Rathborne Village Residents Committee
C/O 13 The Waxworks
Rathborne Village
Ashtown
Dublin 15
D15 YX92

27 October 2022

Subject: DART+ West Railway Order Application

**BUILDABILITY DESIGN  
COMPOUND ACCESS ROUTE  
ASHTOWN LC**

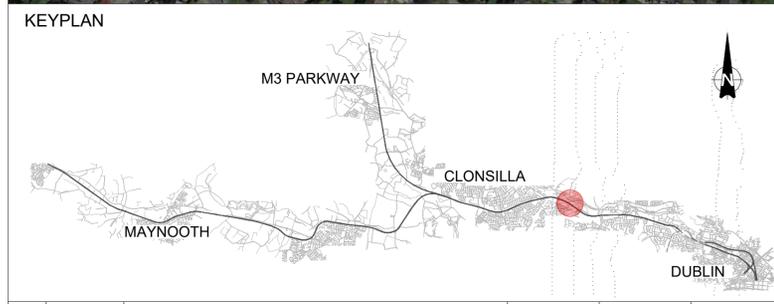
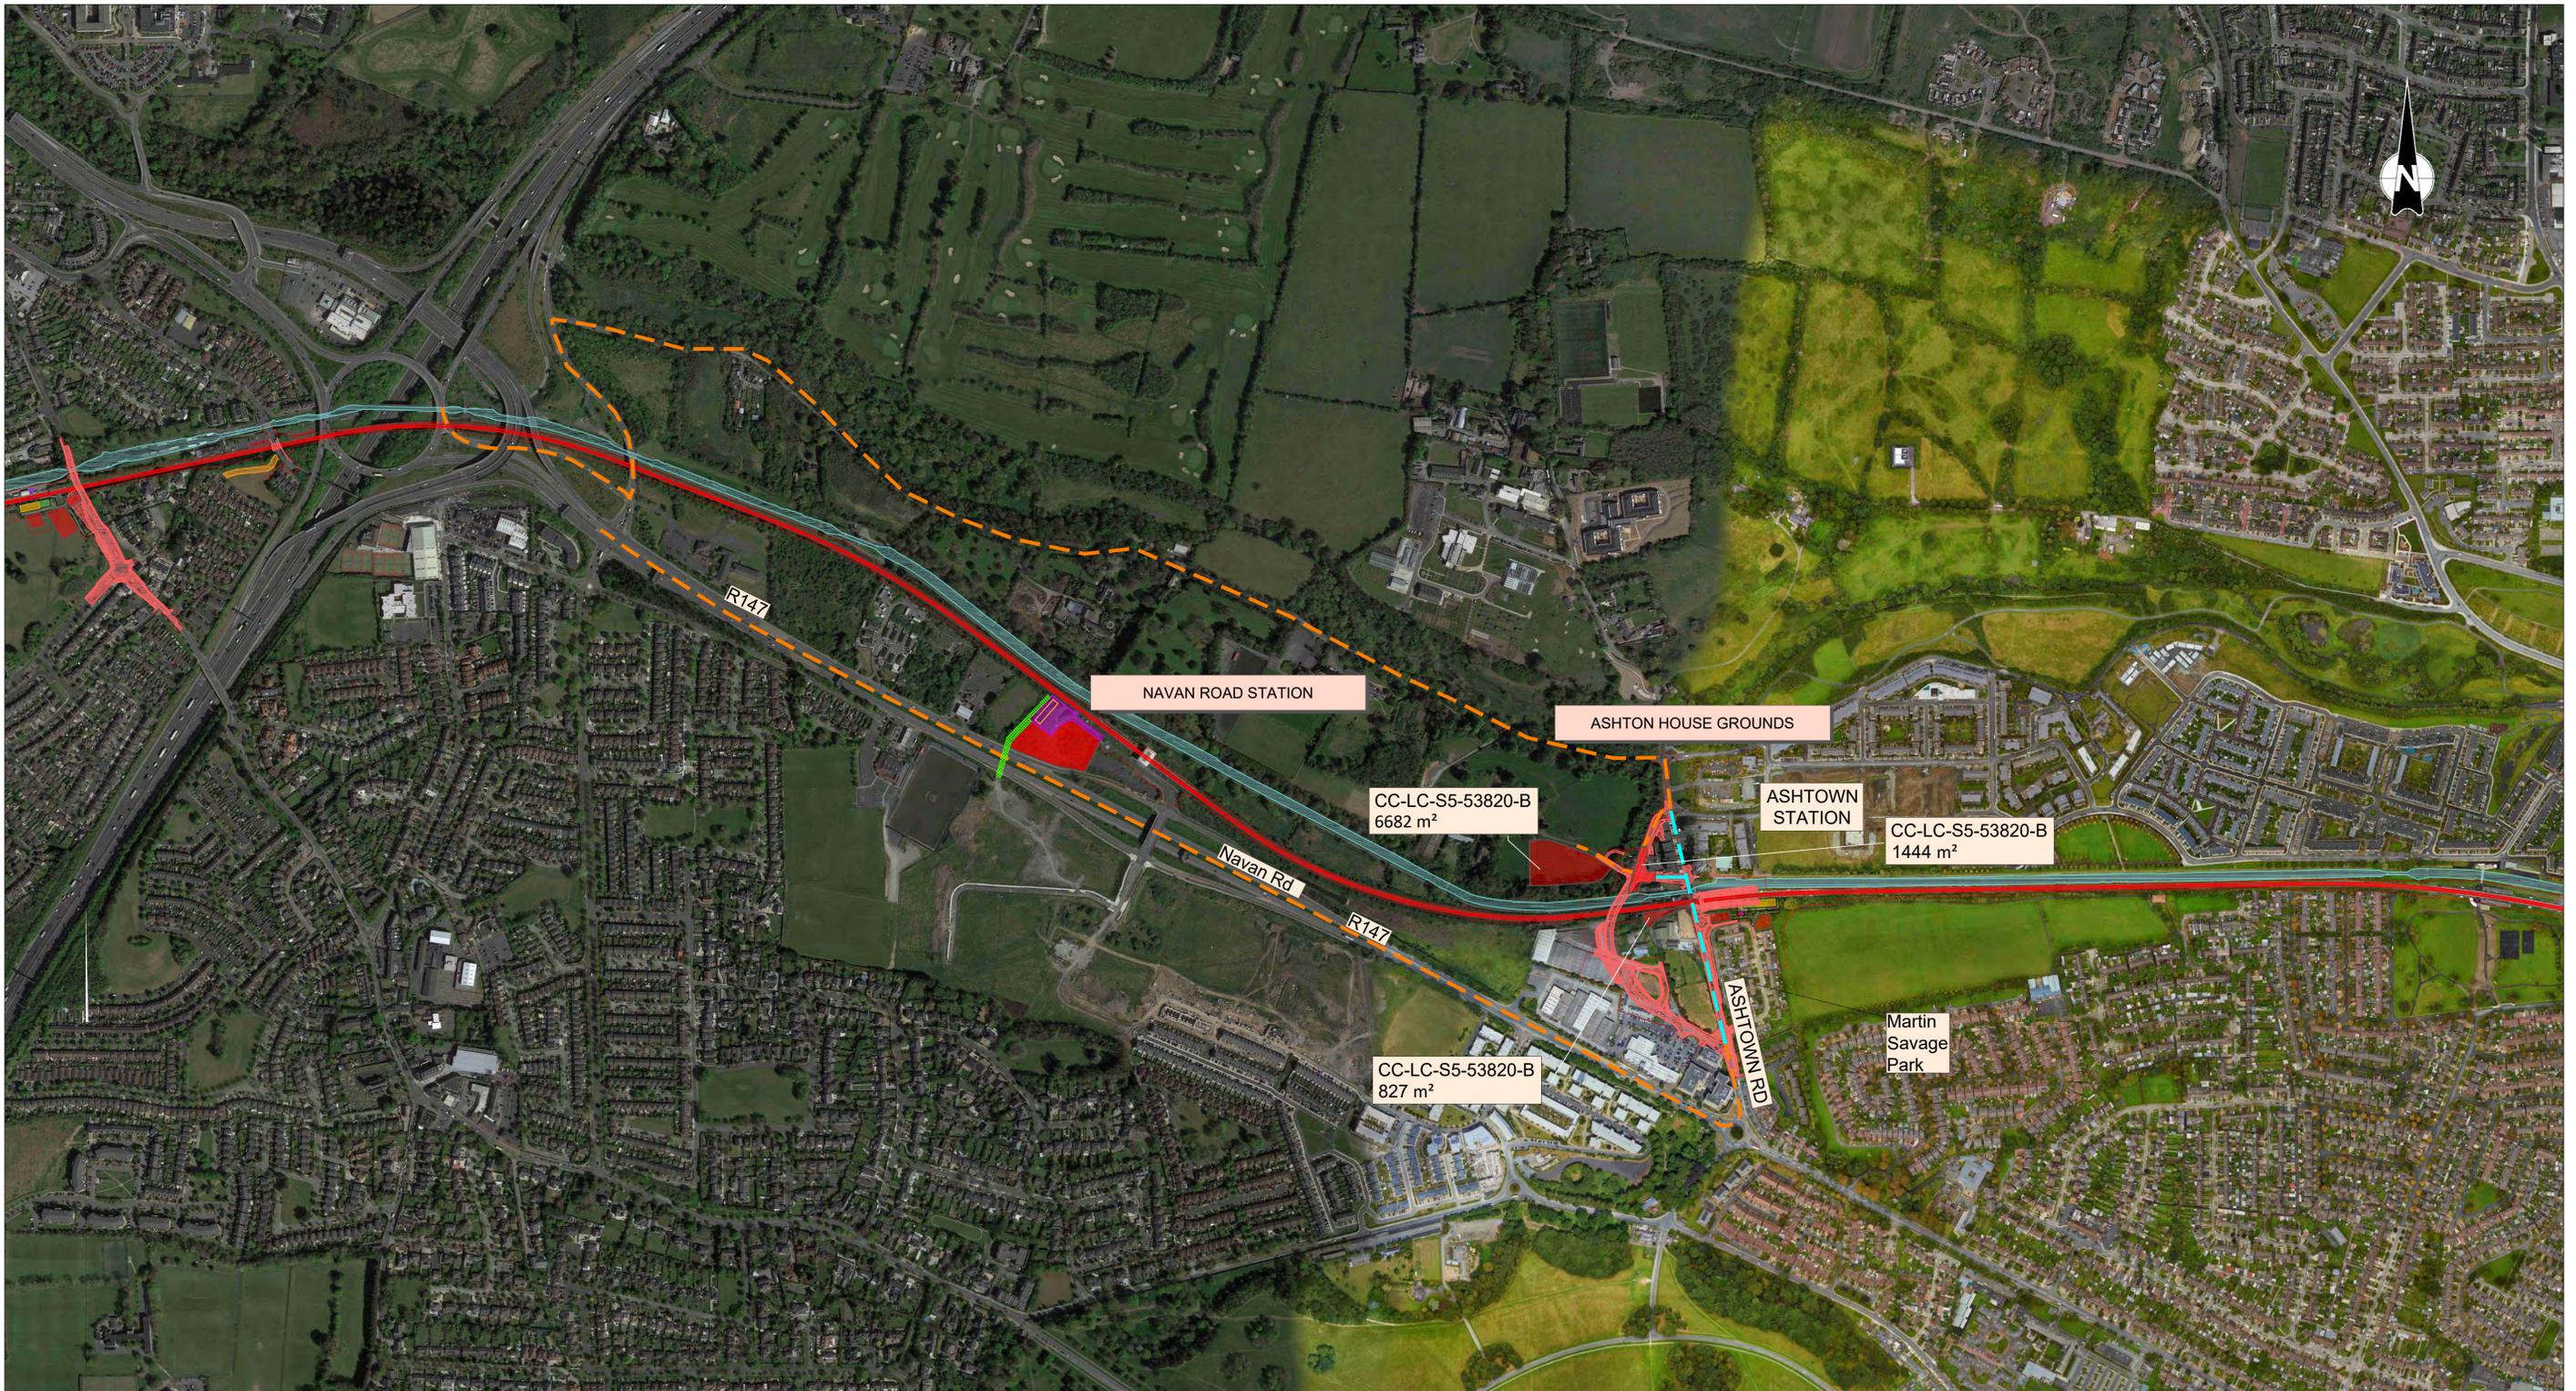
We propose that any approval of the railway order application is subject to the condition that Irish Rail take steps, including engagement with local Gardai, Dublin City / Fingal County Council/ and Councillors and the local community (1) to find solutions to minimise the risk of anti-social behaviour around new infrastructure and (2) engage proactively where issues of anti-social behaviour arise during the operational phase.

It is unclear why some trees need to be removed, such as along Ashtown road to the South, while we believe that a number of changes to the plans and more careful consideration of design at Ashtown could reduce tree and vegetation loss as well as the carbon footprint of the scheme. While we hope that a more in depth assessment of the need for the scale of tree and vegetation removal across the whole project area and in Ashtown would be conducted, two non-exhaustive suggestions and queries in relation to Ashtown are included below.
